PLANNING CONSULTATION RESPONSE

Application No	2026/0168
Proposal	Change of use and conversion of part of a sales/display area (Use Class E) to create 1no. residential unit (Use Class C3)
Address	Unit A, Priory Arms Rotherham Road, Cundy Cross, Barnsley, S71 5RF
Date of Consultation Reply	15/04/26
Consultee	Highways DC

PROPOSED

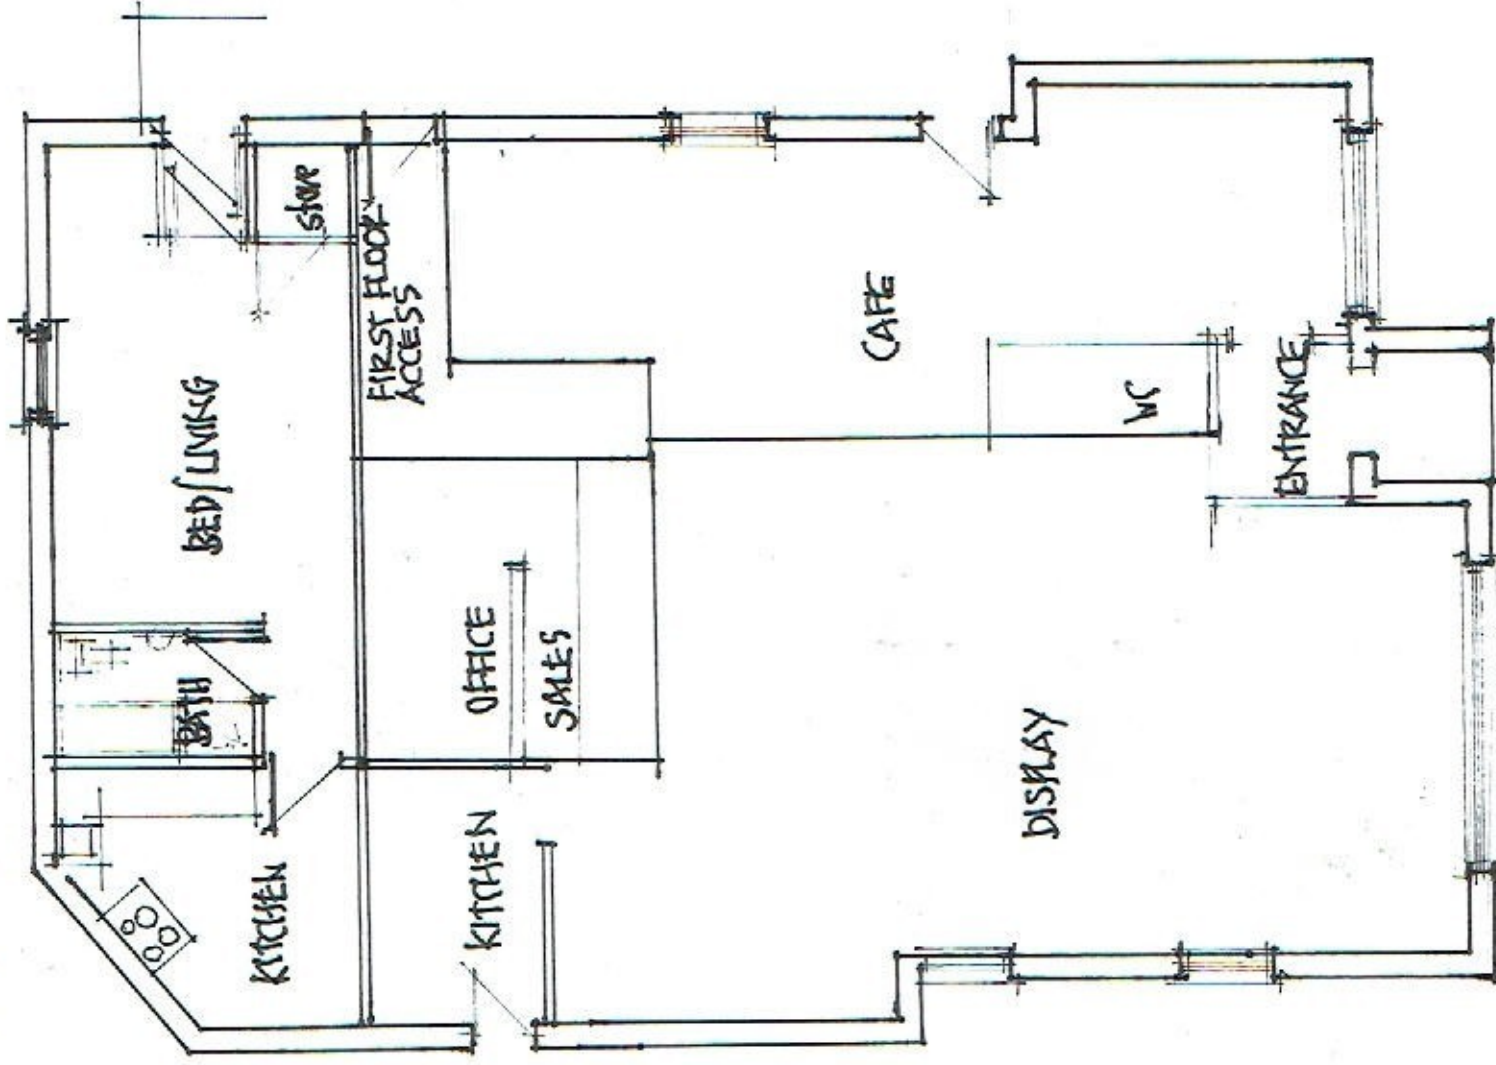
It is suggested that there will be no change to the existing car park, but one space should be reserved for the resident and the manner in which this is to be achieved should be submitted by the applicant.

Although the layout drawing is labelled with a proposed cycle store and bin store, the dimensions of these have not been shown. The bin store should be of sufficient size to accommodate three residential bins alongside the existing commercial facilities; the cycle store should be covered, capable of being made secure and subject to regular surveillance as per the advice in the Council's Parking SPD. As such, additional details should be provided for the proposed cycle store, and both facilities should be dimensioned on a plan rather than just being imprecisely labelled.

The existing and proposed car park has been marked out in the layout drawing as having 12 spaces without any changes being anticipated. However, on-site observations show the car park is not presently marked out as per the submitted drawing. The layout should therefore be amended to reflect the actual car park layout and include the above-requested details of resident parking, bin storage and secure cycle storage before HDC officers provide further comments.
